On behalf of 200 Lomas LLC, Tierra West would like to notify you that we are pursuing three (3) individual Development Hearing Officer (DHO) – Waivers for the property located at 200 Lomas Blvd NW, 87102.

Project Number: 2019-002639

200 Lomas NW

SUBJECT: Sketch

AS101

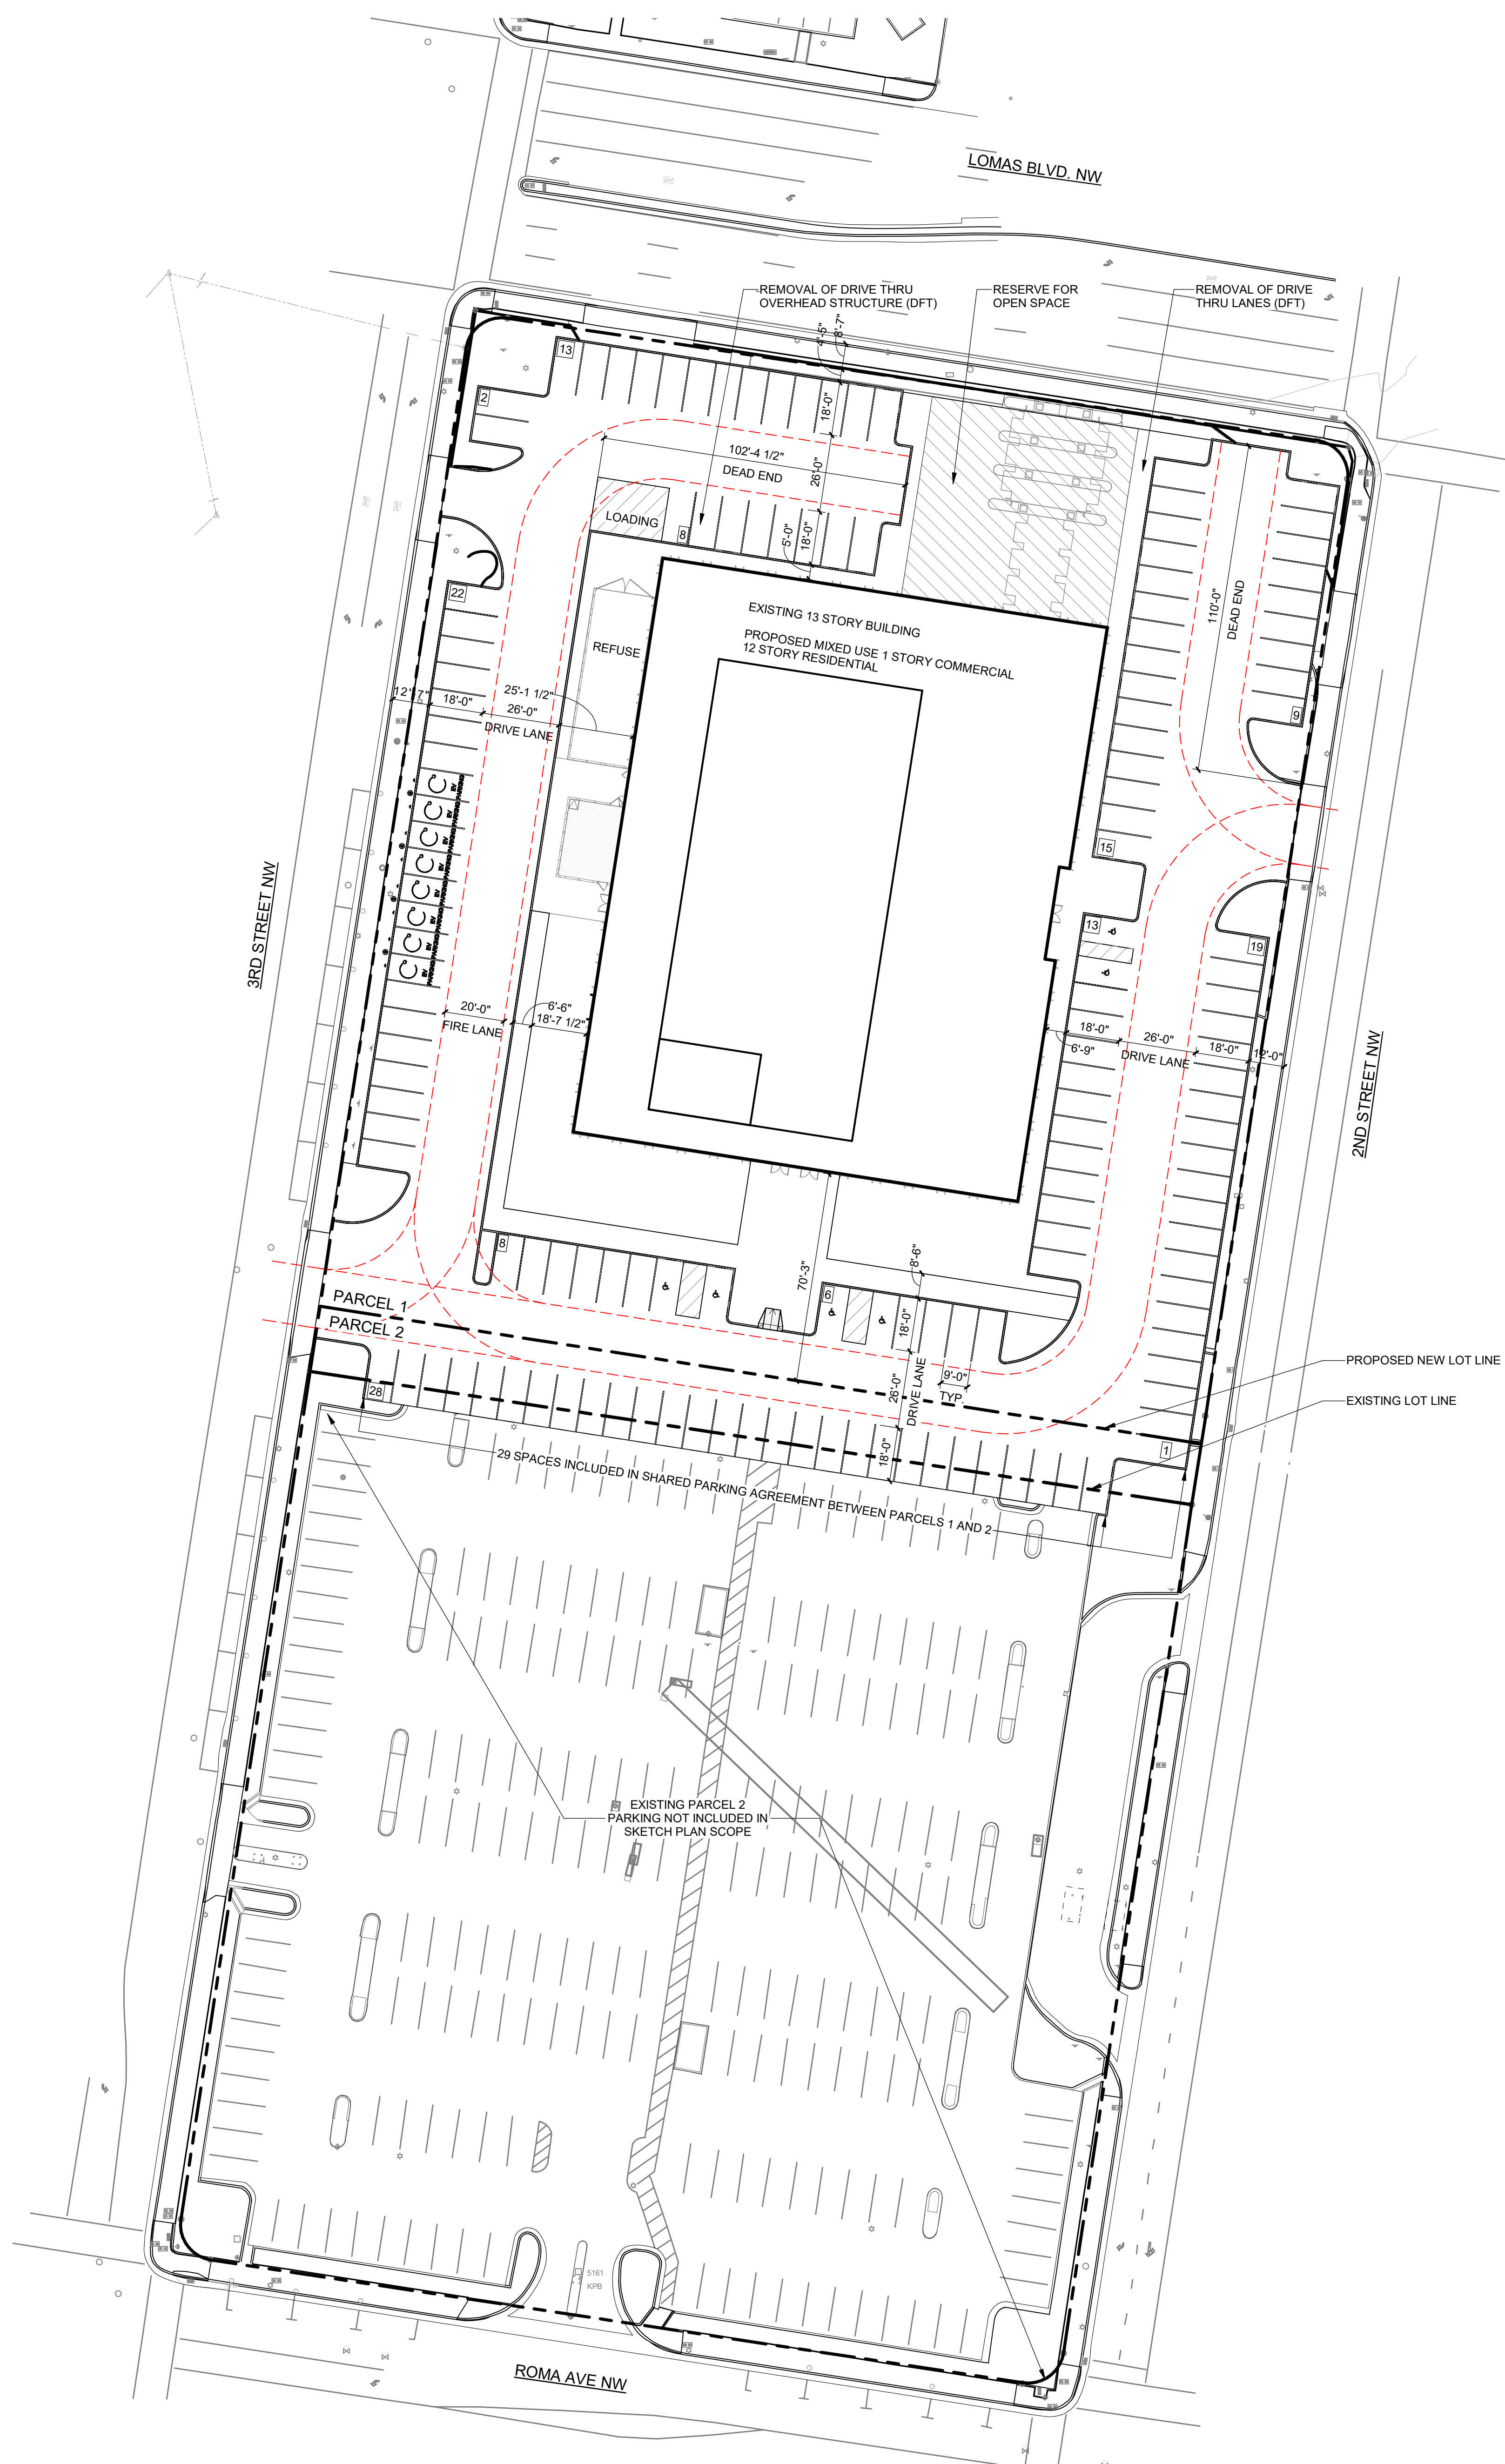
1. Lomas, 2nd, and 3rd are Principal arterial require 10' sidewalks and 6'-8' landscaping buffer. Existing widths are 7' along 2nd and 3rd, 8' along Lomas, require to be widened to 10'.
2. Roma is local road requires 5' sidewalk and 4'-6' landscaping buffer, the existing 7' sidewalk is in compliance.
3. Any future development will require an approved TCL prior to site plan or building permit. Also, a Traffic Scoping Form would need to be submitted to determine if a TIS would be required.

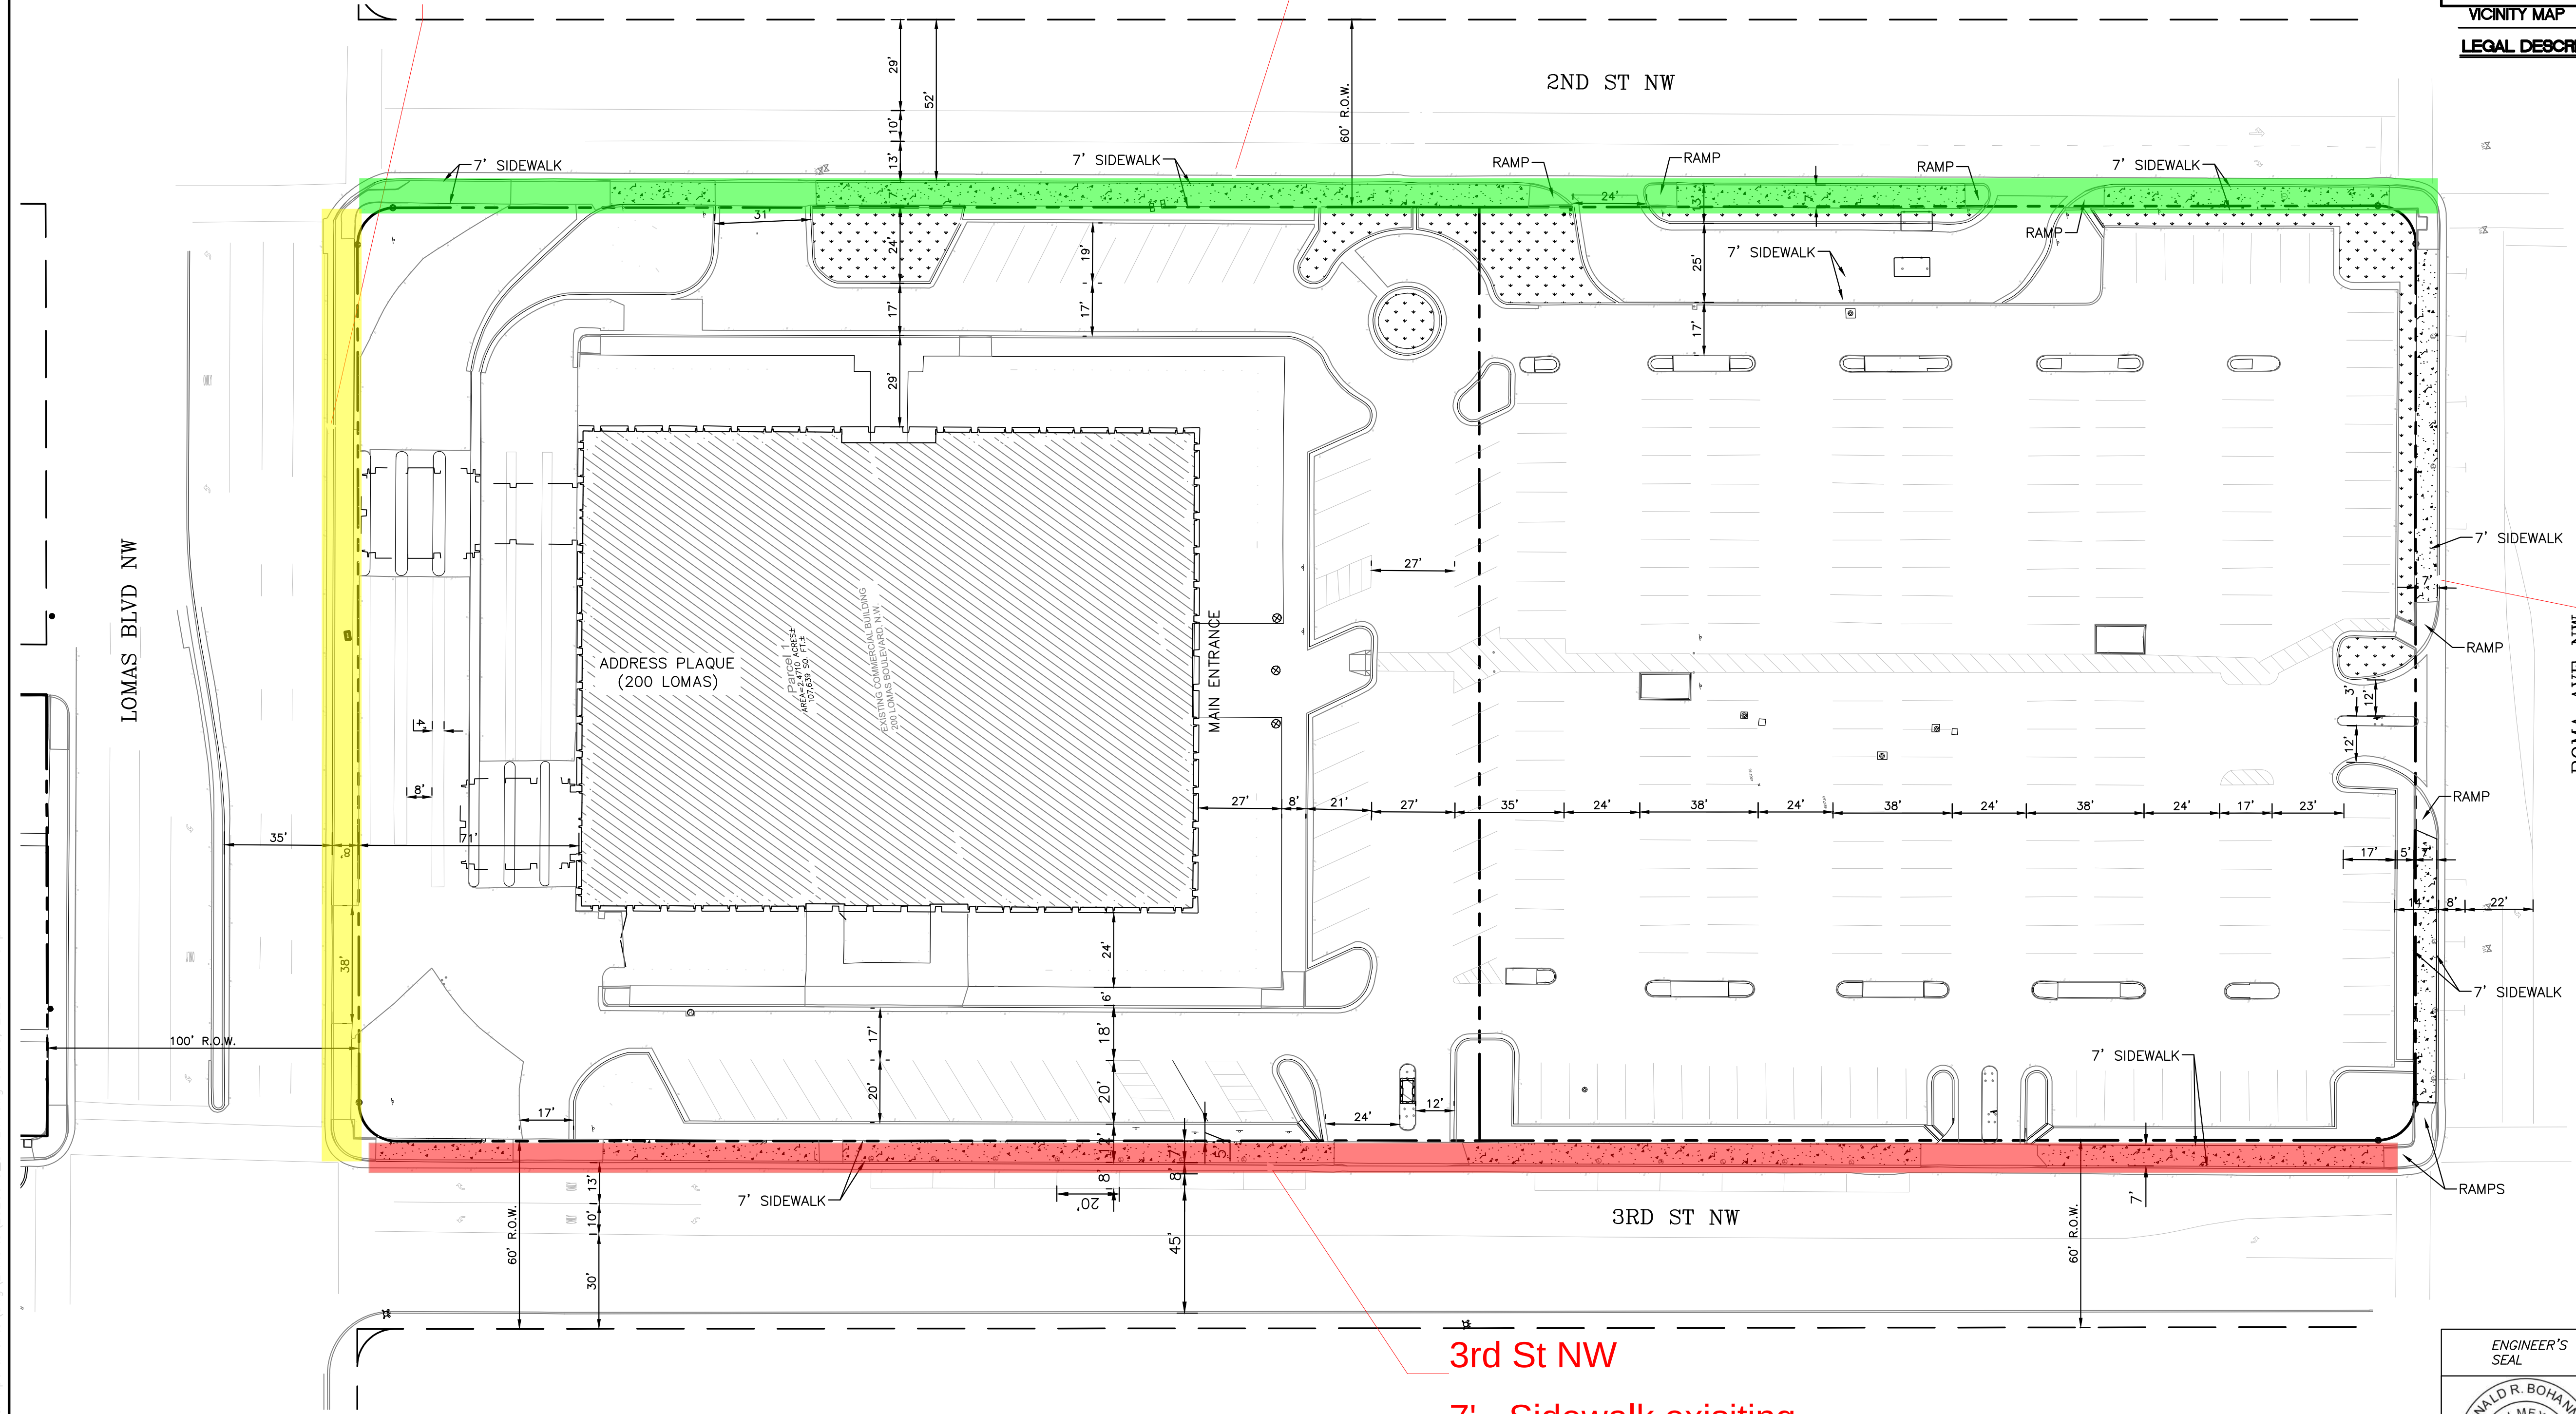
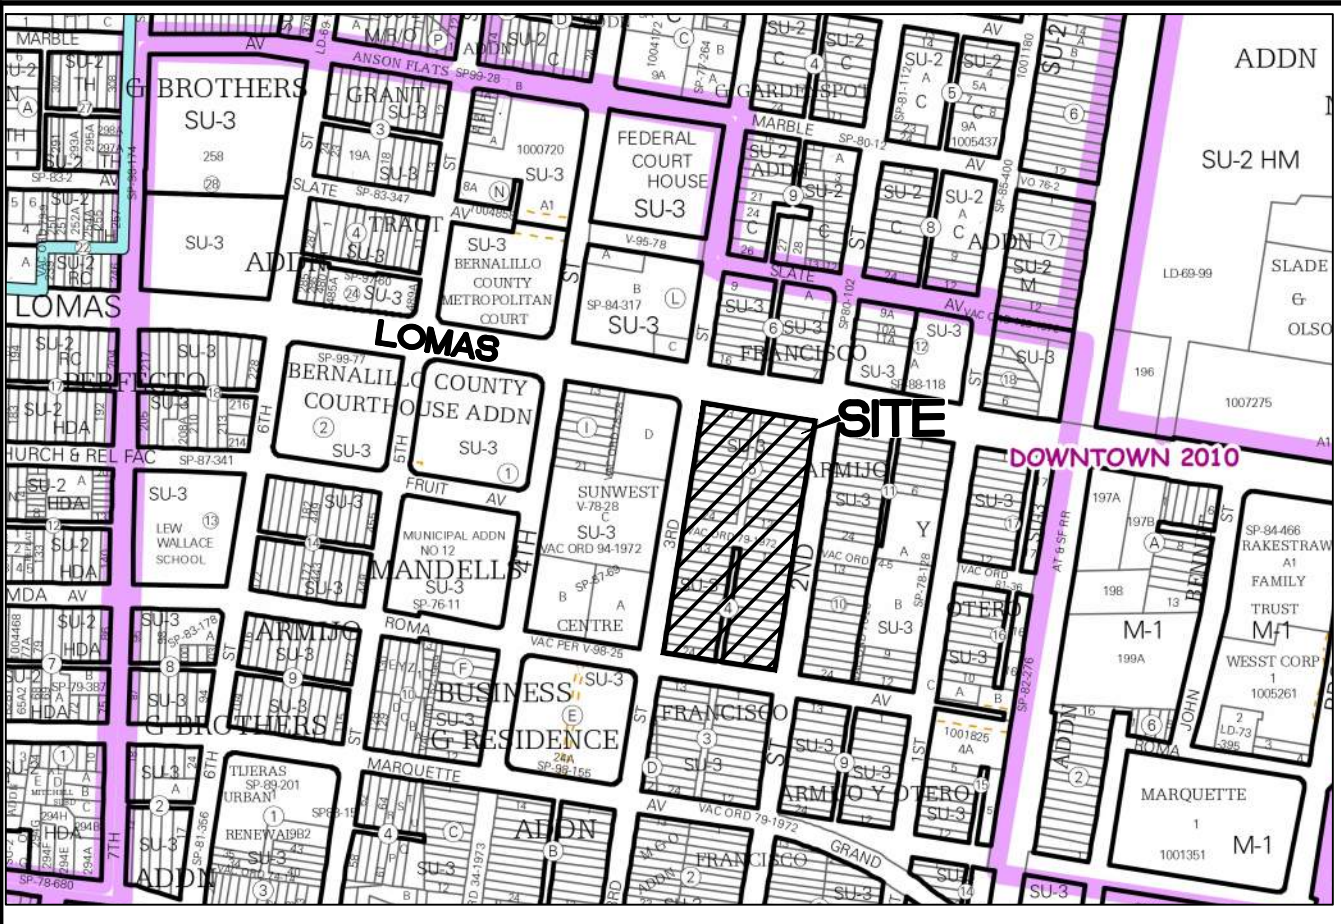
- **Lomas Blvd** – Existing width: **7'-0"** → **Requested waiver: 3'-0"**
- **2nd Street** – Existing width: **7'-0"** → **Requested waiver: 3'-0"**
- **3rd Street** – Existing width: **7'-0"** → **Requested waiver: 3'-0"**
